Application for a non-material amendment following a grant of planning permission.

<input type="text" value="Single storey side and rear extension and front porch."/>	
Reference number:	<input type="text" value="21/00047/FULL"/>
Date of decision	<input type="text" value="19/02/2021"/>

The proposal is render the proposed extension and lower part of the existing dwelling. The upper part of the dwelling to be cladded with composite panels.

Drawing Number
 655-106

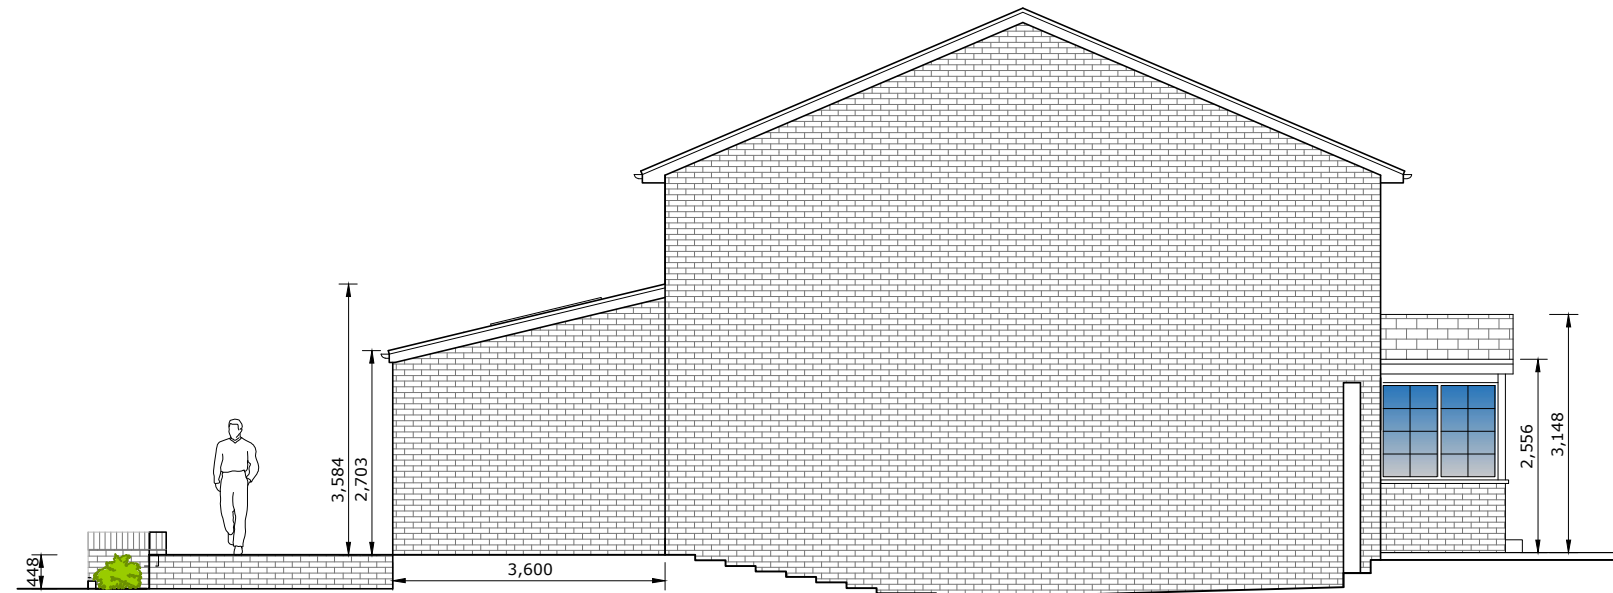
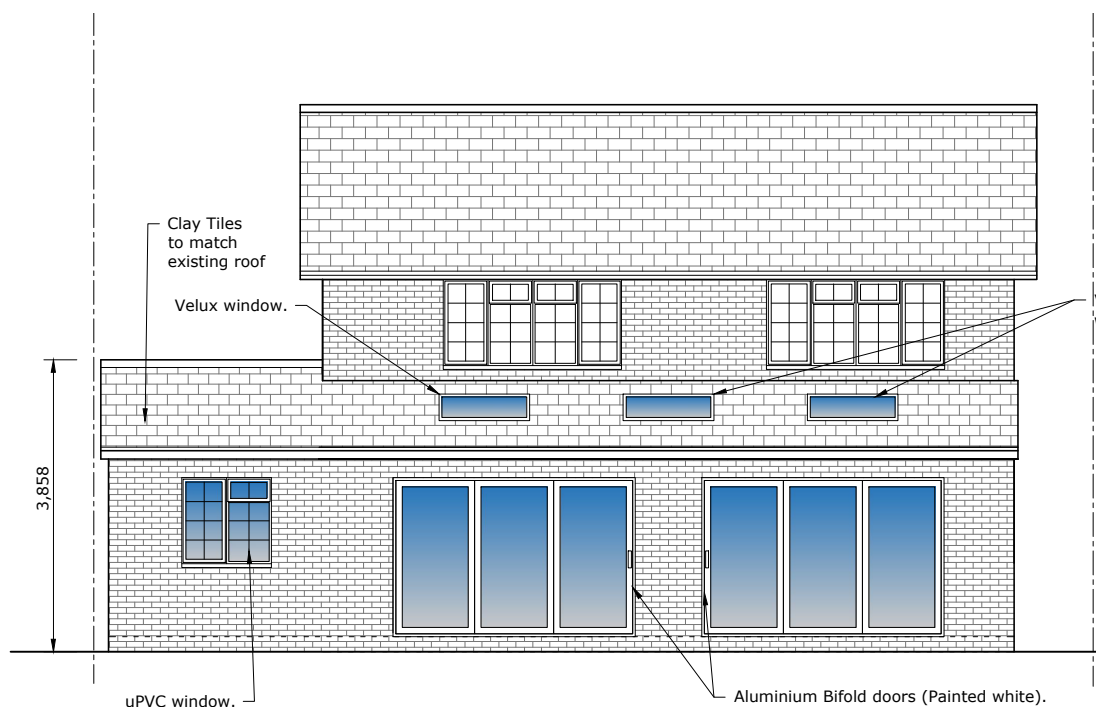
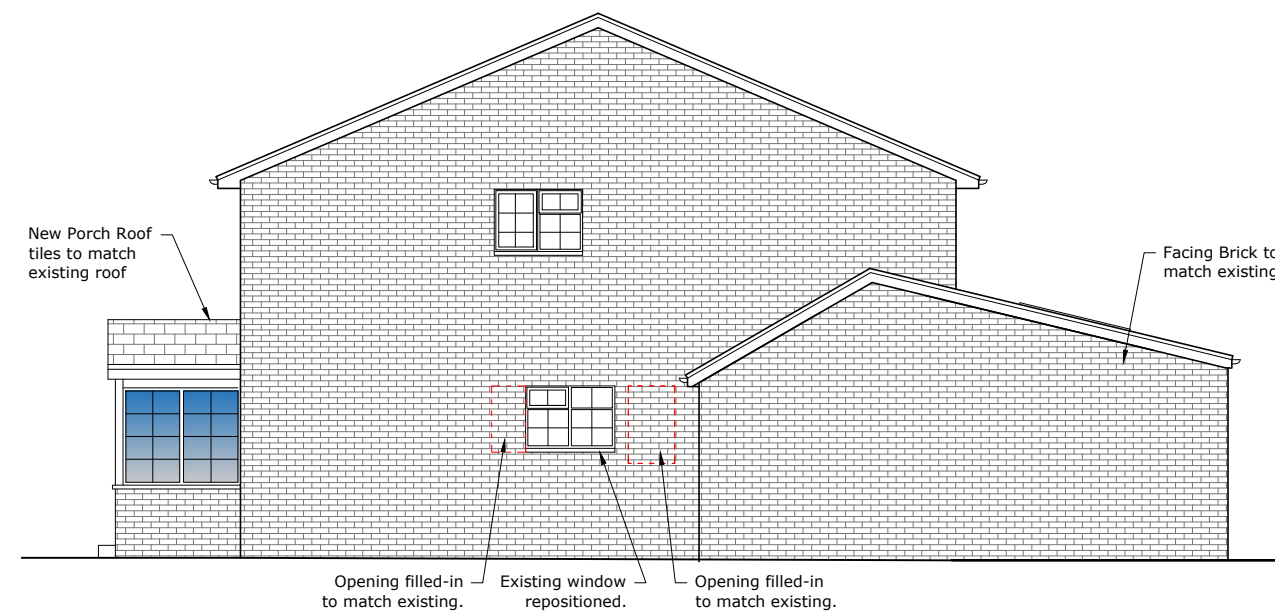
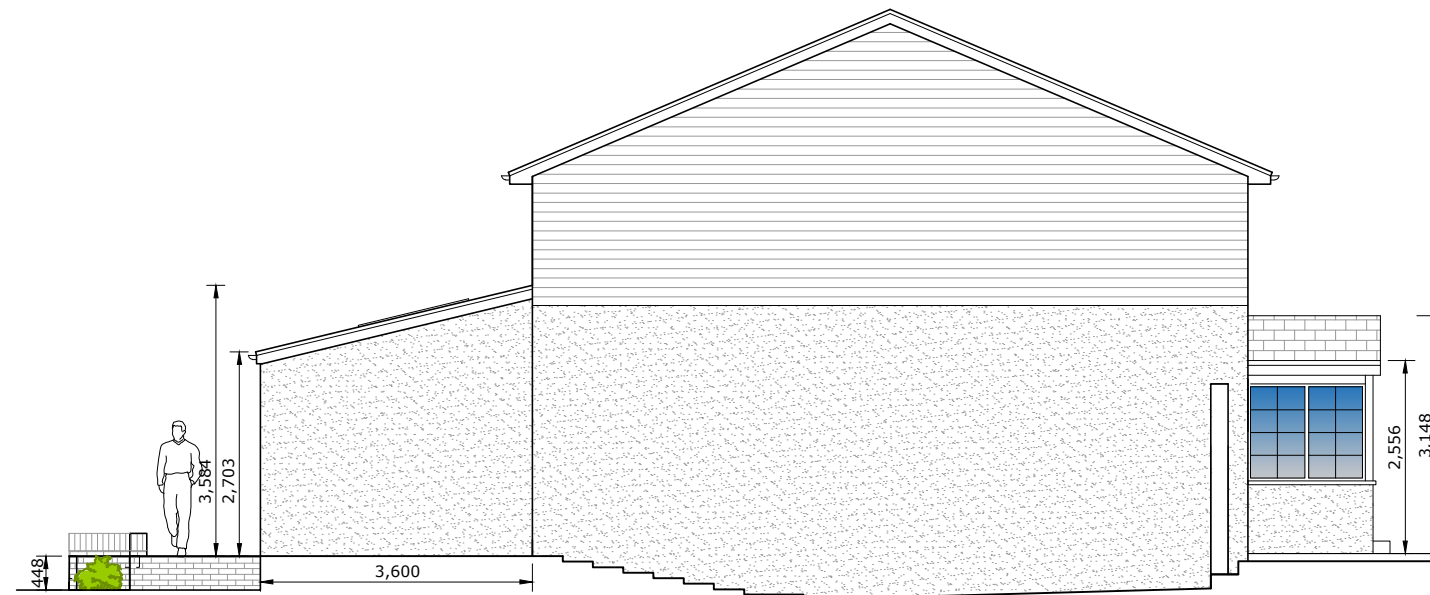
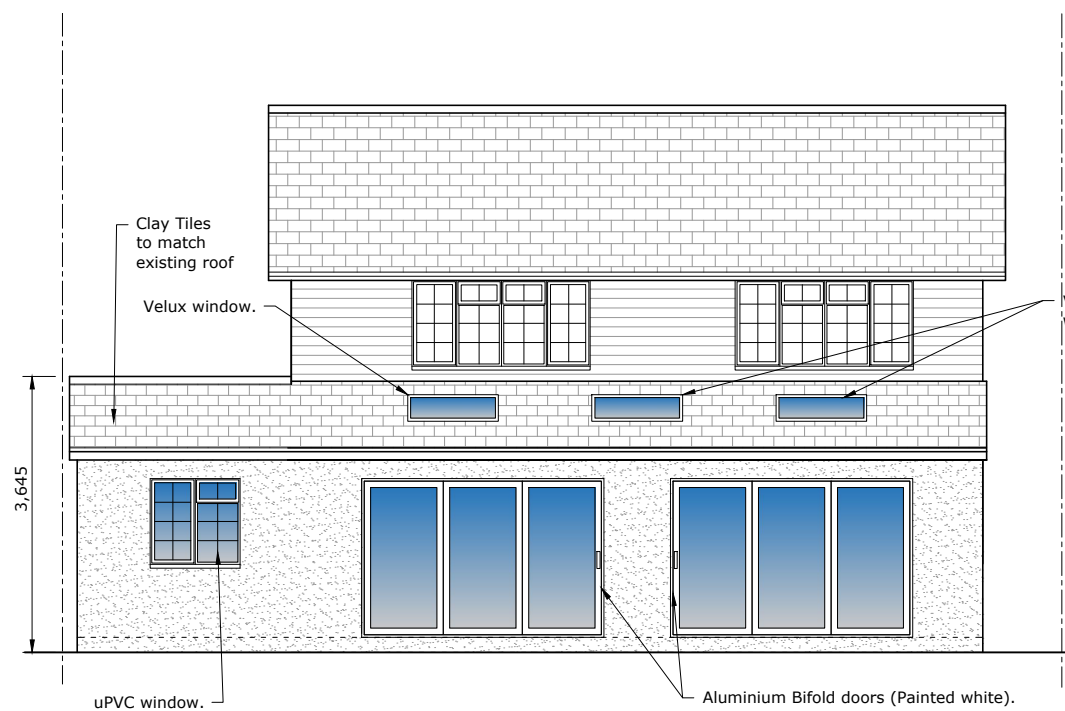
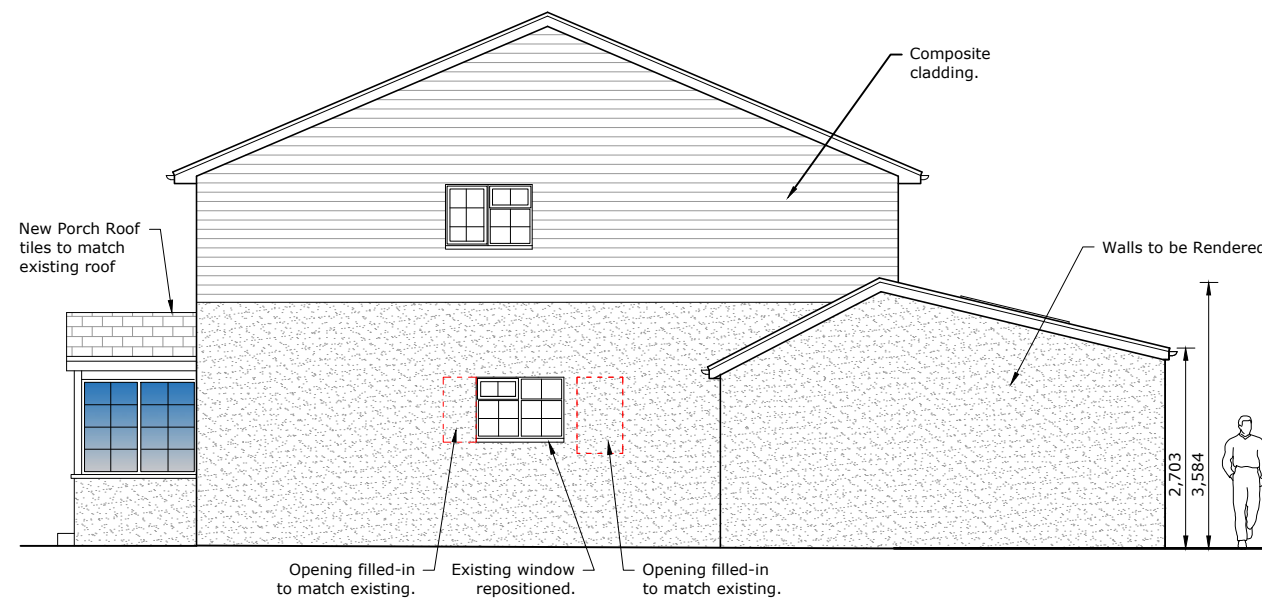
655-105-Rev01

655-106
